# City of Albuquerque Stormwater Construction Site Inspection Report

Project Name:	Puerta Del Bosque				
Location:	Campbell & Rio Grande				
Site Contact Name & Agency	Steve Hernandez - Sivage	ESC File No.	G12E035		
	<a href="mailto:steve@dmcnm.com">steve@dmcnm.com</a>	NPDES Id. No.	NMR10013N		
Inspection Date:	06/10/19	Start/End Time:	1145/1200hrs		
CoA Stormwater Inspector:	Timothy E. Sims				
Construction Phase:	Home construction				
Type of Inspection:	<input checked="" type="checkbox"/> Regular	<input type="checkbox"/> Storm Event	<input type="checkbox"/> Post Storm Event >0.25"	<input type="checkbox"/> 311/Complaint	<input type="checkbox"/> Follow Up

EROSION AND SEDIMENT CONTROL PLAN

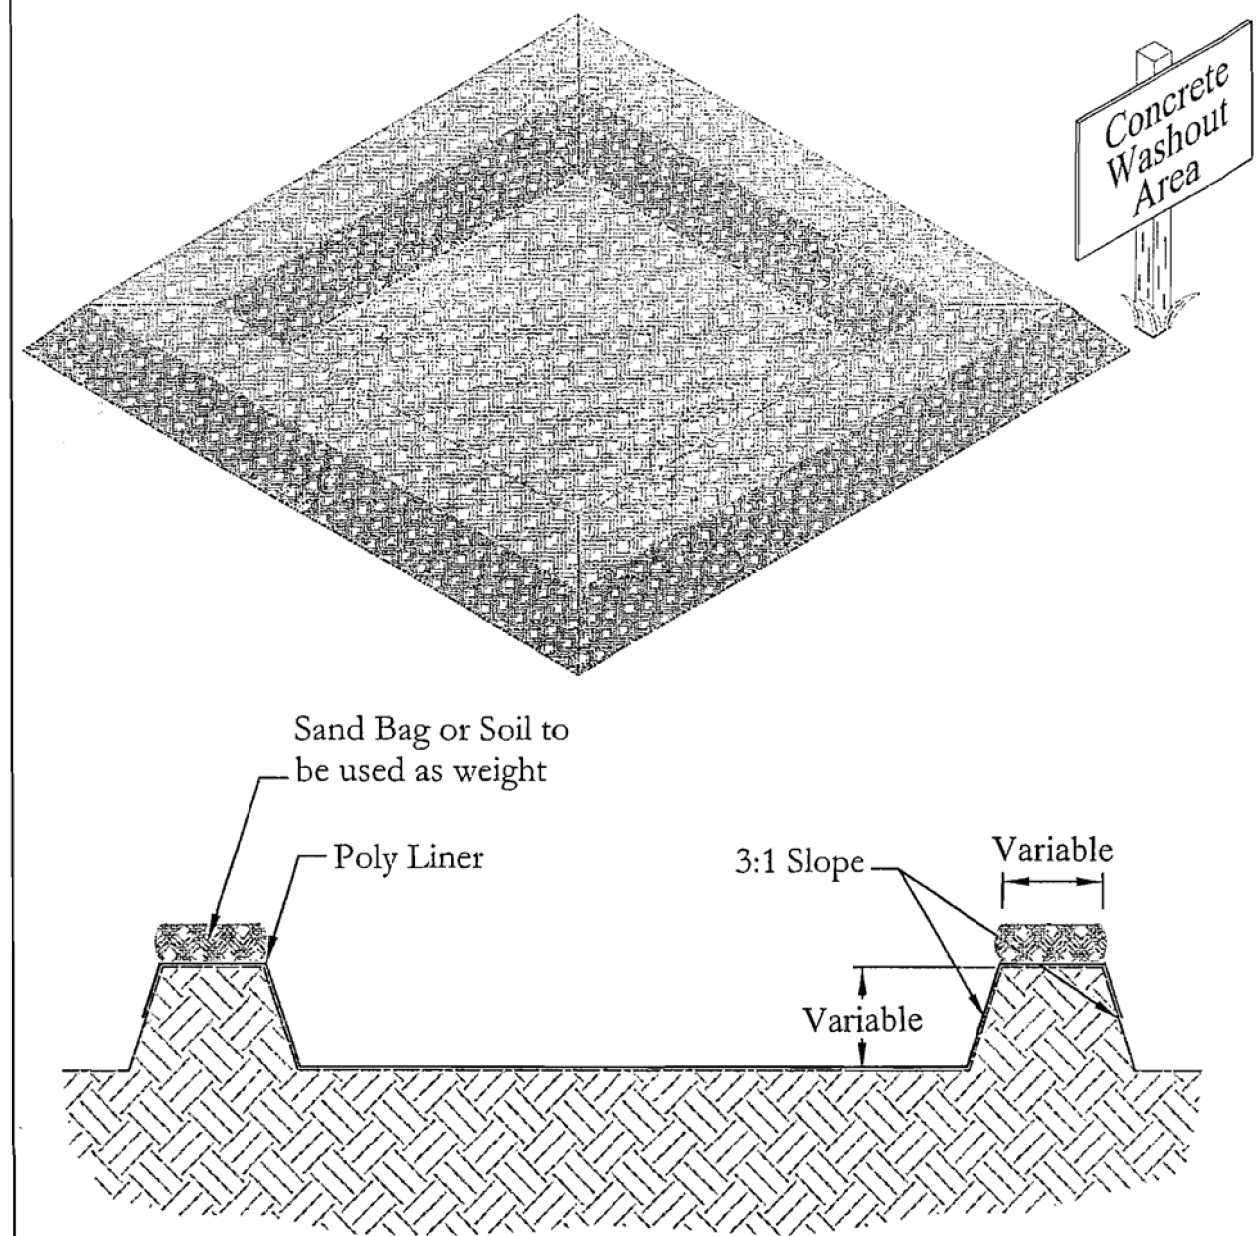
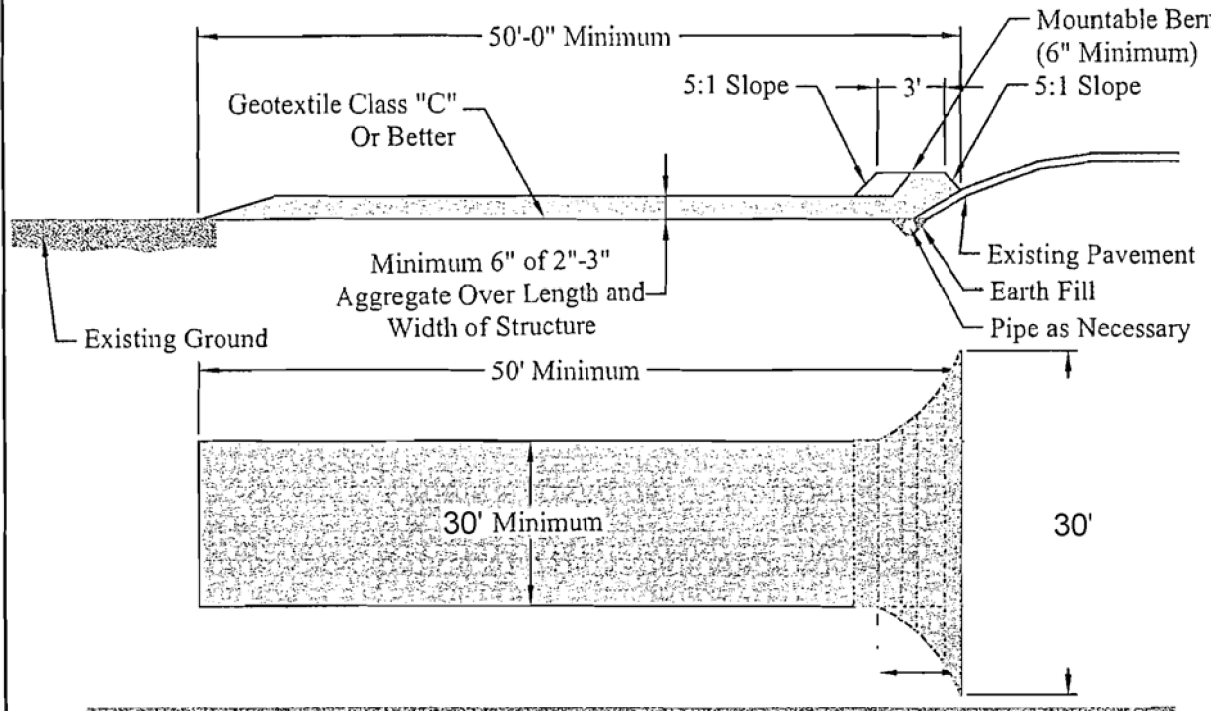
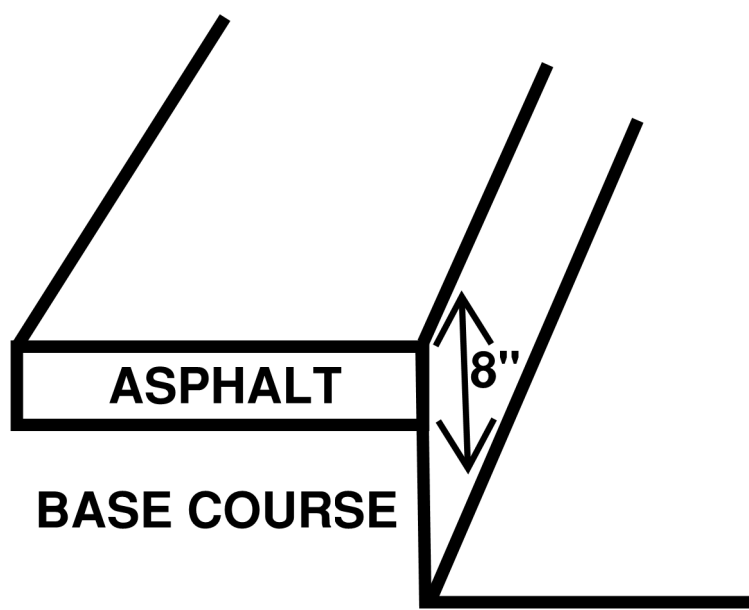
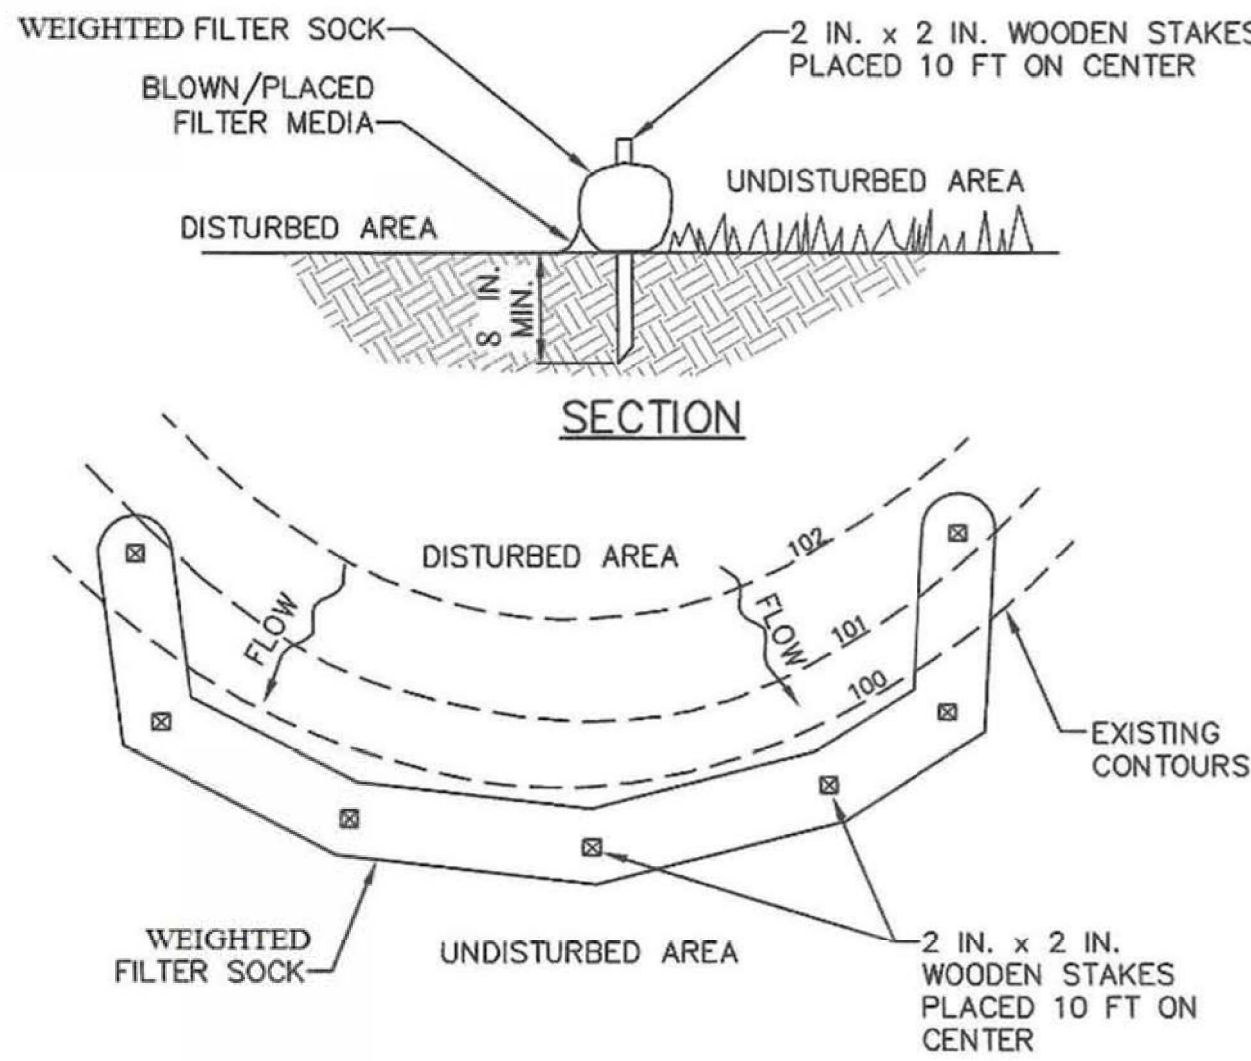
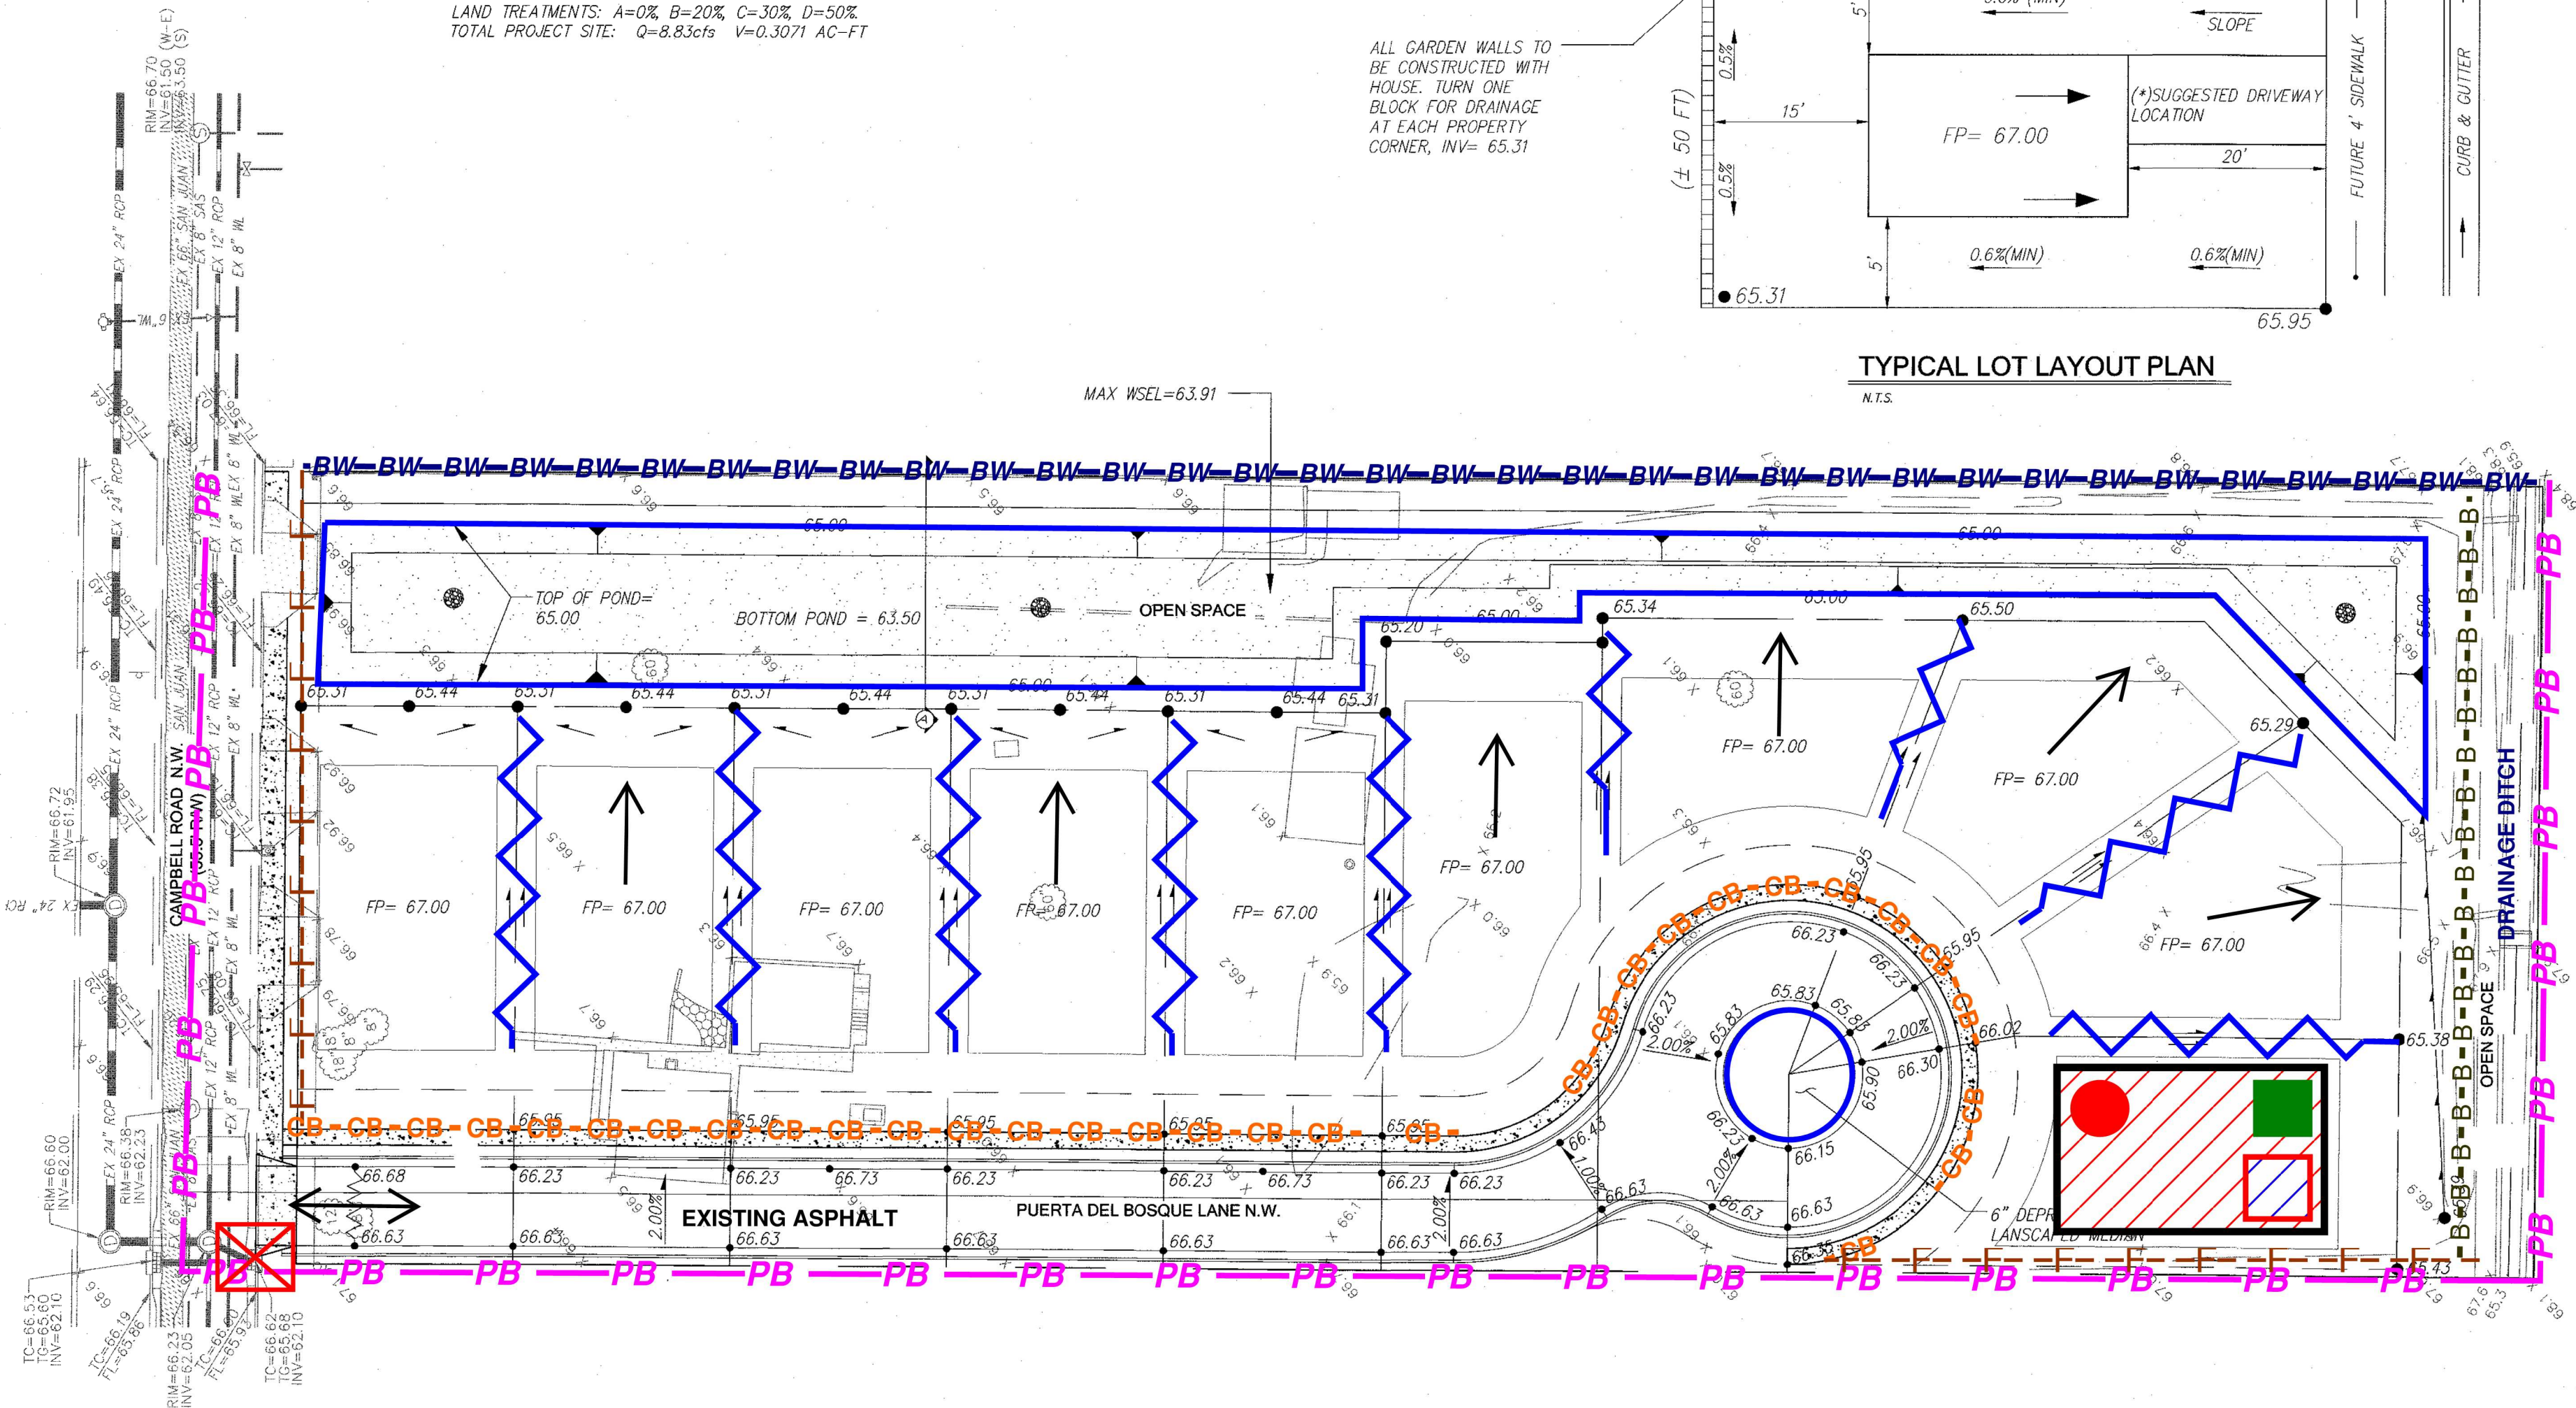
Item Number	Deficiency/ Corrective Action		
1	Numerous washout on several lots - please mitigate		
2	Concrete washout facility requires maintenance and posting. Please post facility.		
3	Please provide latest SWPPP self-inspection report		
2.1	Discharge off site? (Y/N)	No	
4	Self Inspection Reports	requested	Latest report Date:
